Please could you upload the e-mail below to the application folder BE/70/20/DOC as a consultation response from ADC Drainage Engineer?

Condition 6- surface water drainage design

FLOW CONTROL CHAMBER DETAIL  
ORIFICE PLATE

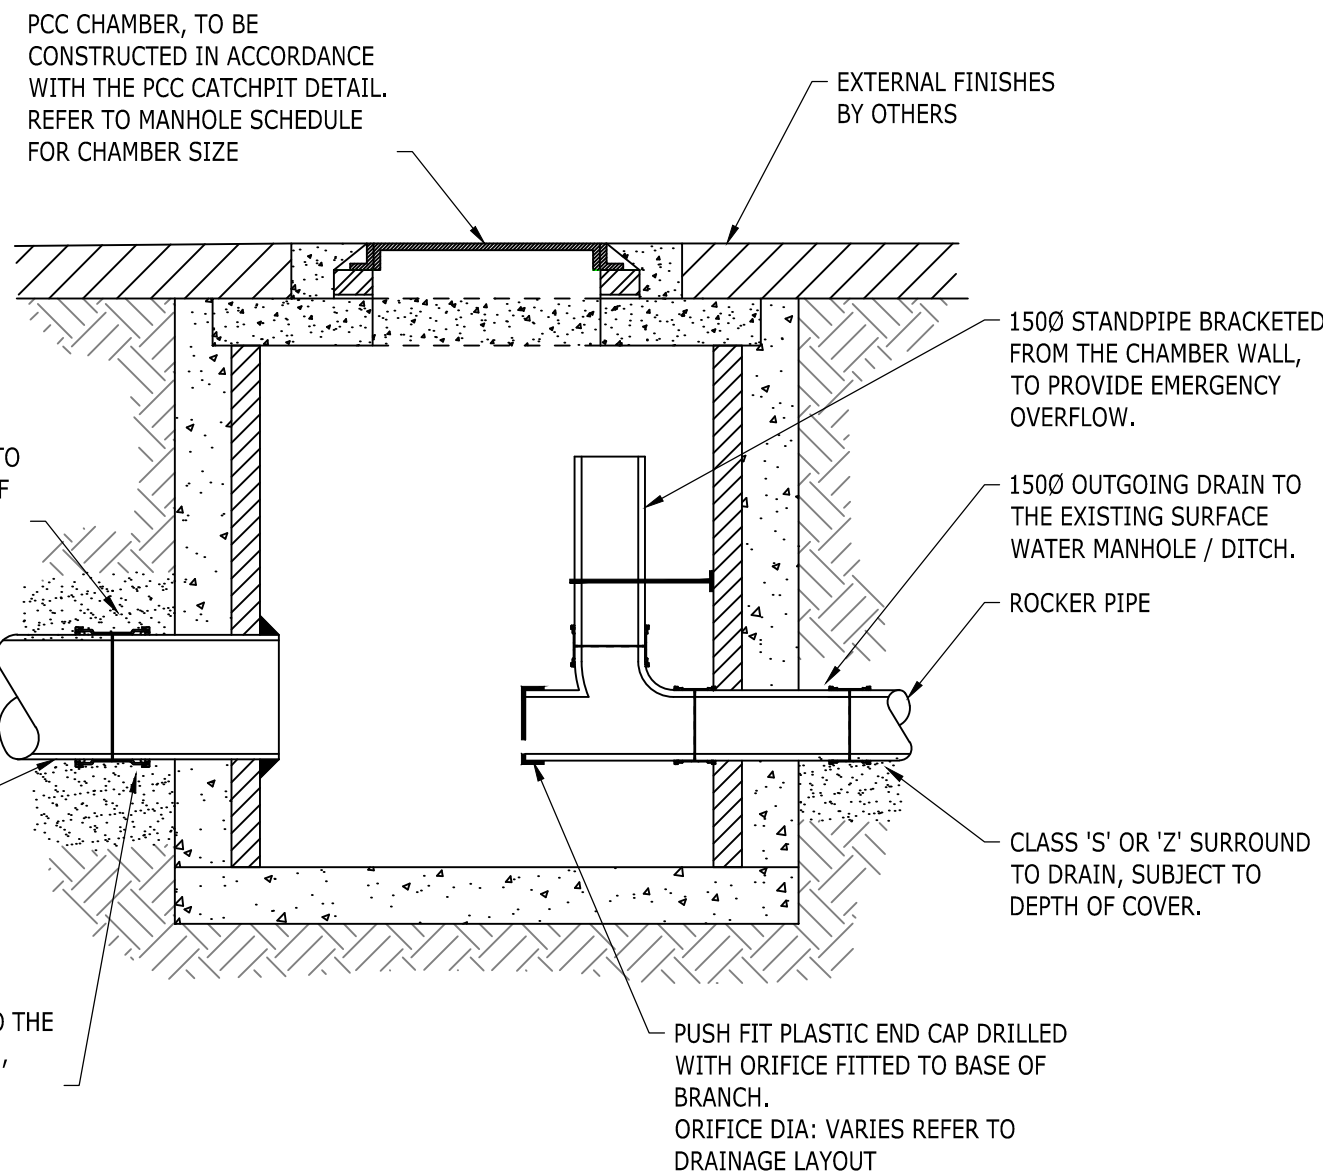
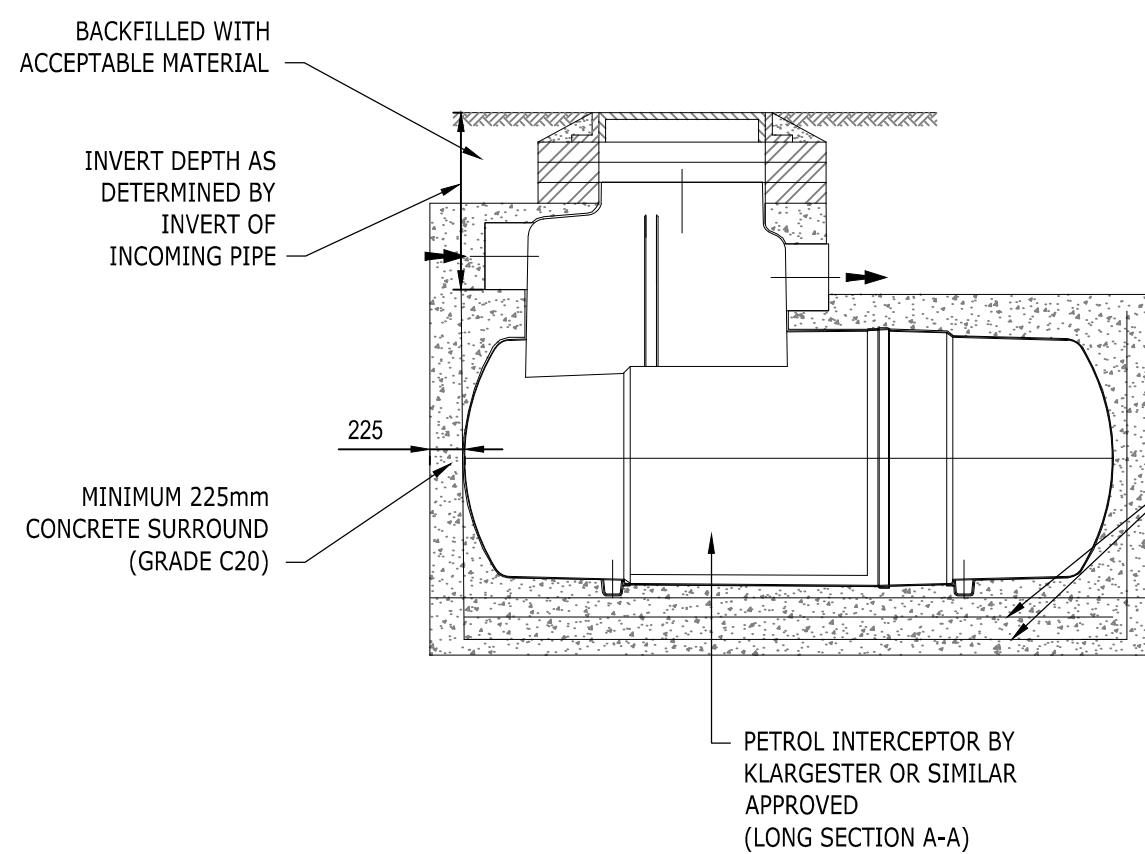
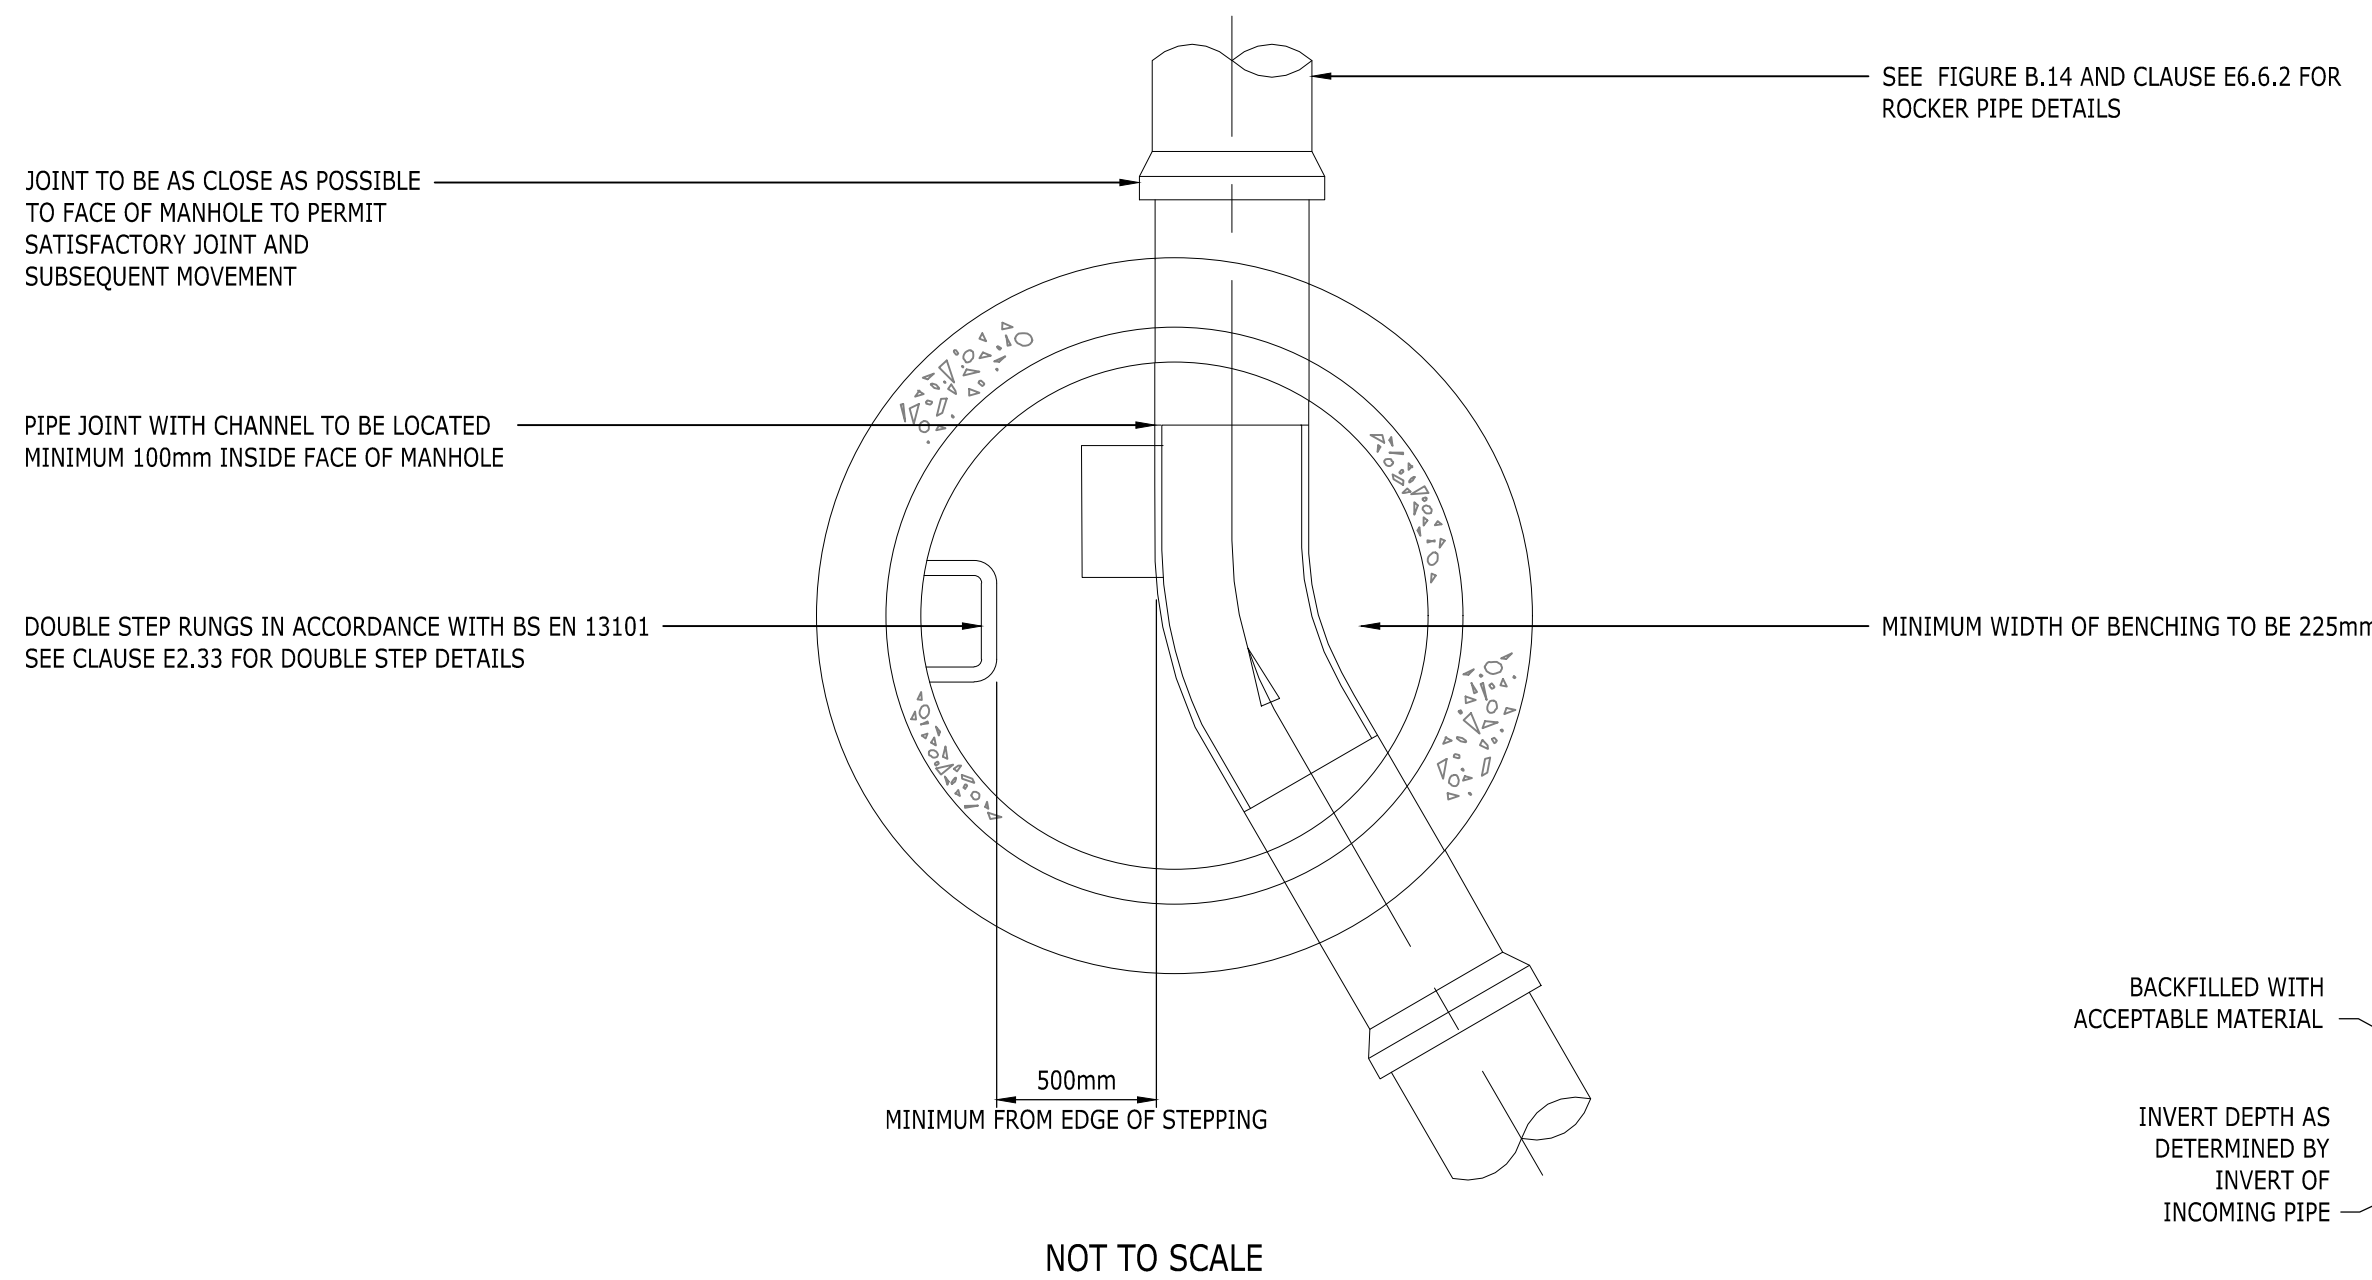
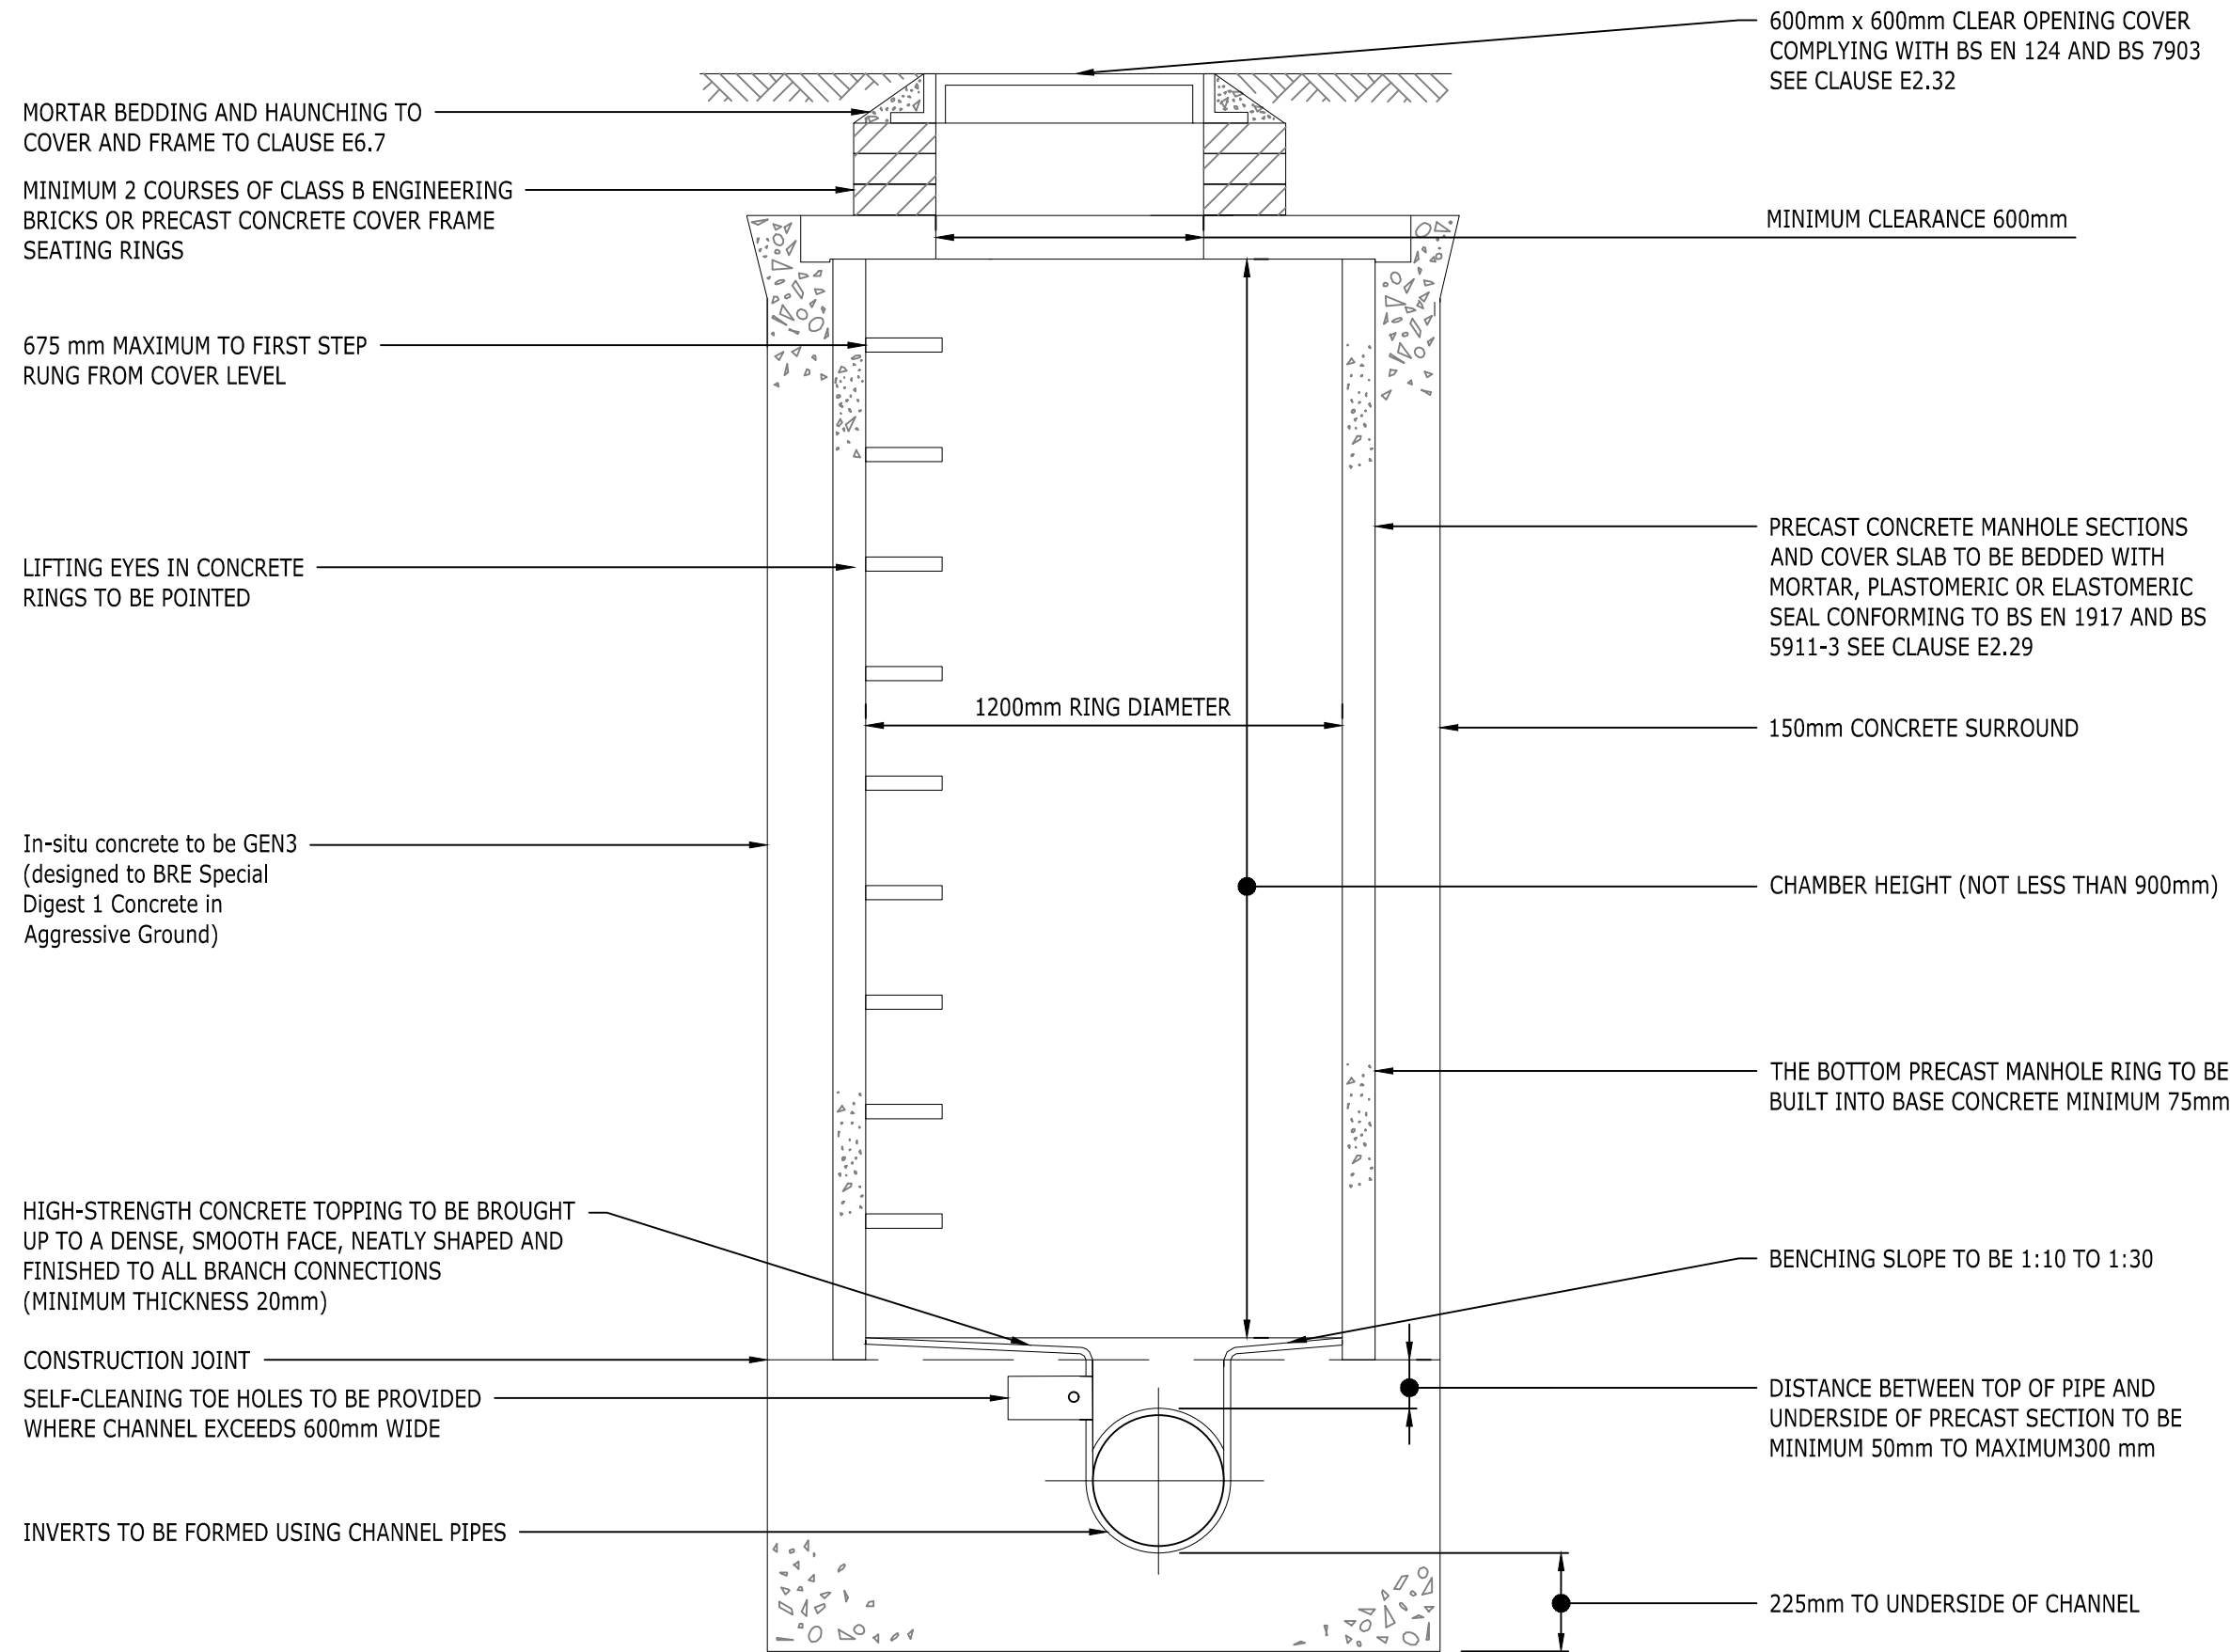
5. A construction detail drawing should be provided for each of the proposed flow control devices, i.e. one of the hydrobrake with overflow at MH9 and one of the orifice at MH7. These should be site specific, with orifice diameters, hydrobrake references and levels specified.

6. Please detail the requirements that the full detention separator must meet. E.g. size, standards.
